The Secretary,
An Coimisiún Pleanála,
4 Marlborough Street,
Dublin 1.

Our Ref. SCA/01/26
Your Ref. ACP-324322-26
4th August 2026

Re: Substitute consent for the retention of demolition at lower ground floor, ground floor and first floor levels and the substantially constructed part two/ part three storey extension at the north elevation of the existing dwelling and a new on-site sepcan waste water treatment plant with and polishing filter, and percolation area.

Tara Hall, Balscadden Road, Howth, Co Dublin

Rev.	Date	By	Description
Scale	1 : 250		Job Title
Date	DEC. 2025		PROPOSED WORKS AT TARA HALL, BALSCADDEN ROAD, HOWTH, CO. DUBLIN
Drawn by	D.C.		Drawing Title
Org. No.	24-1471-02	Rev.	Client
			MR. JOHN ROE

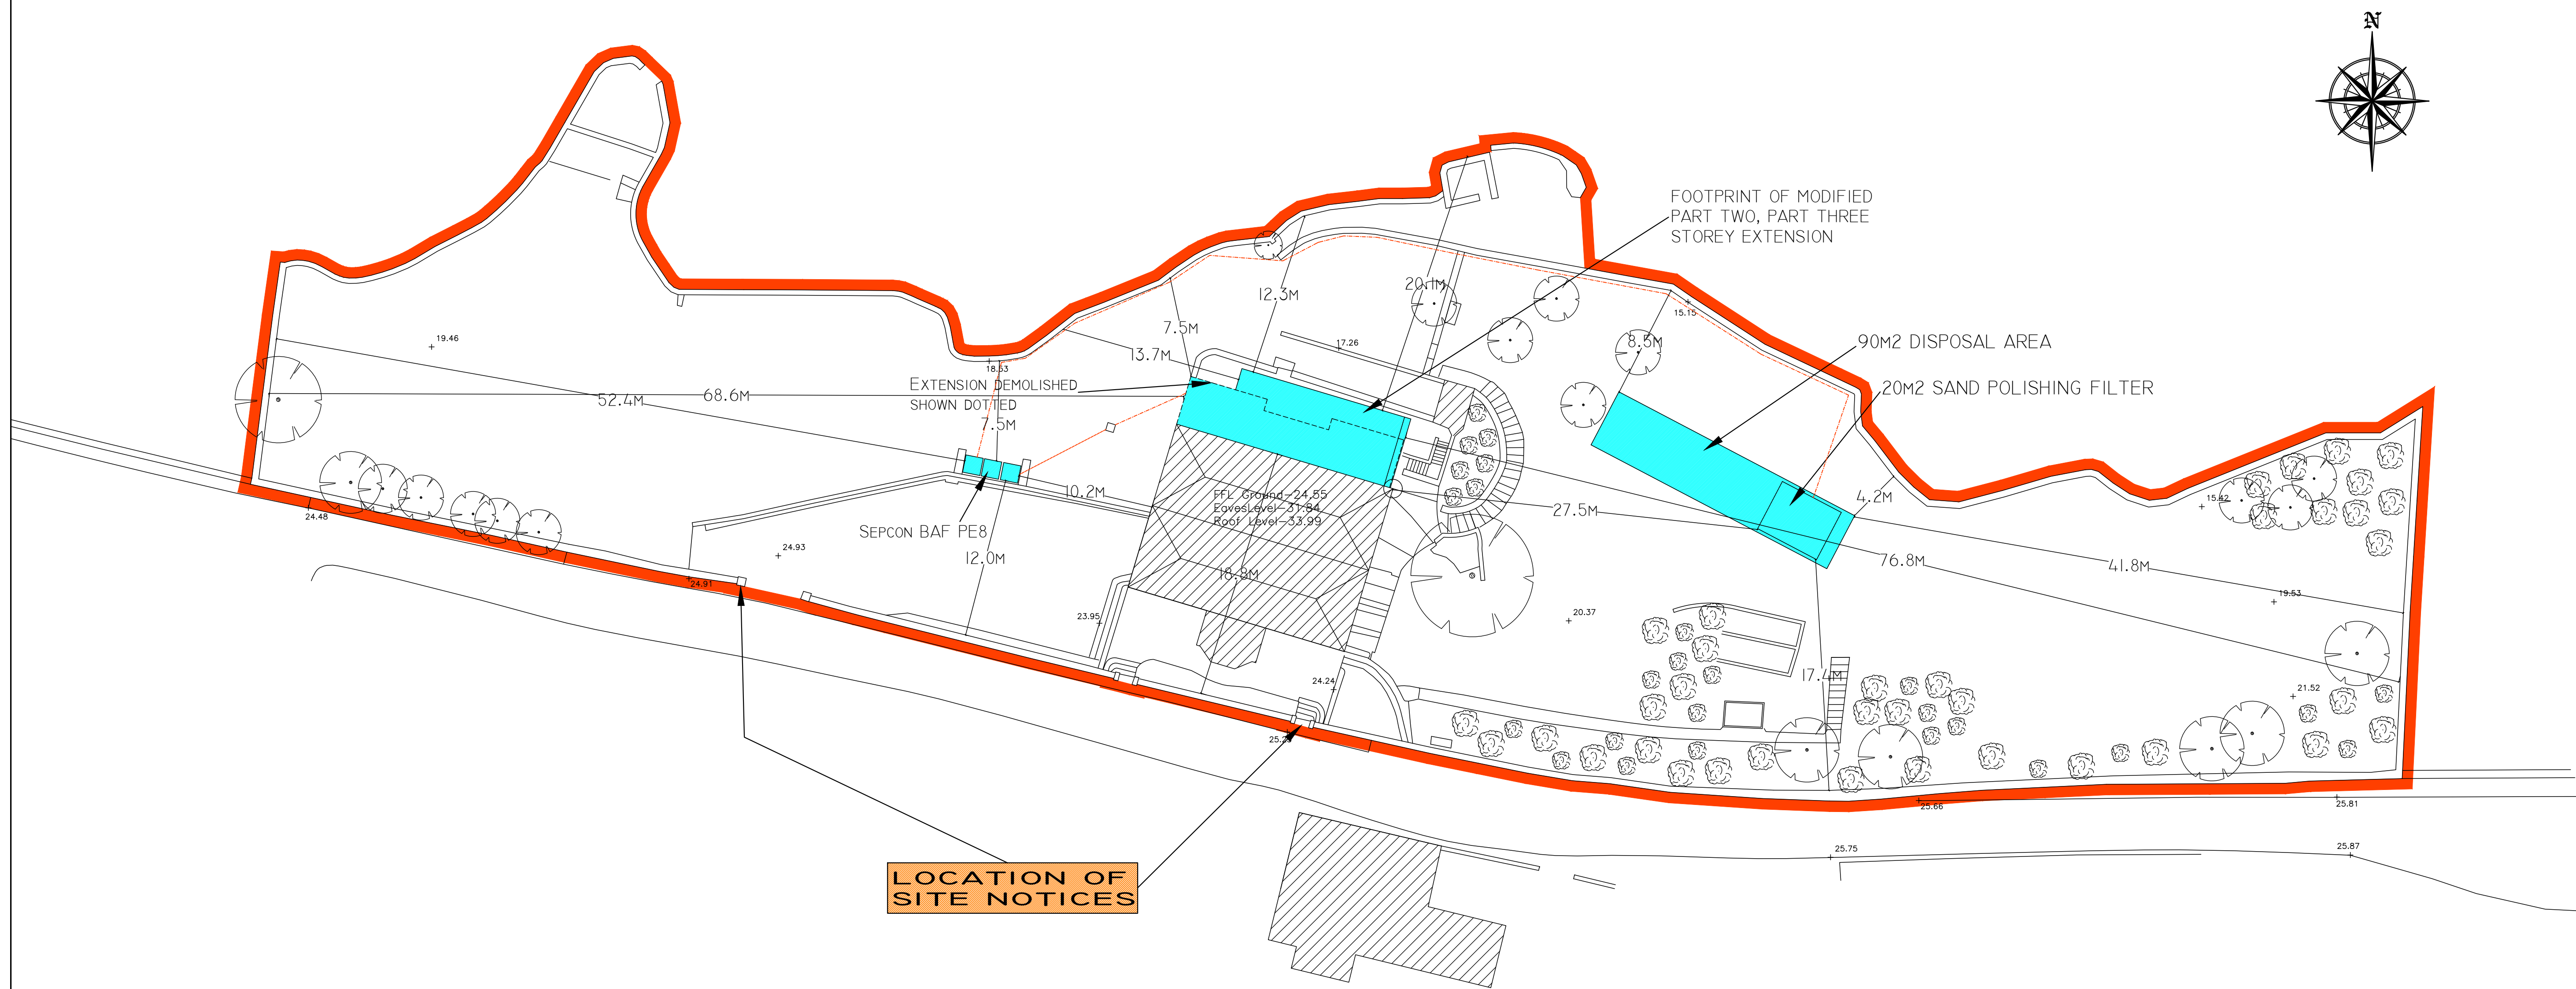
The Annex I habitat 'Vegetated sea cliffs of the Atlantic and Baltic coasts [1230]', is located 4.2m from the WWTP percolation area, as shown in the site layout plan by DaCaD Design, Drawing Number 24-1471-02. The wastewater system appears to be designed to allow wastewater to discharge via percolation into the ground. It is unclear what the quality of discharge will be at this point (discharge to percolation area) and if there is adequate depth of soil available to complete the treatment process, and if the soil itself is suitable in type, nature and depth to treat the effluent. Based on EPA mapping *Rock is at or Near Surface* (EPA, <https://gis.epa.ie/EPAMaps/>, accessed 02/07/26). Additionally, the Remedial AA Screening Report notes stone walls demolished onsite were used to "make up ground for the percolation area". This potential pathway for wastewater treated to an unknown standard, to seep/move downslope during the lifetime of the project towards the cliff face approximately 4.2m away north of the percolation area, is considered to present a risk to the Annex I Vegetated sea cliffs habitat which therefore requires further clarification and/or assessment. A hydrogeological and potentially a hydrological assessment should ideally inform the ecological assessment regarding potential impacts and risk.
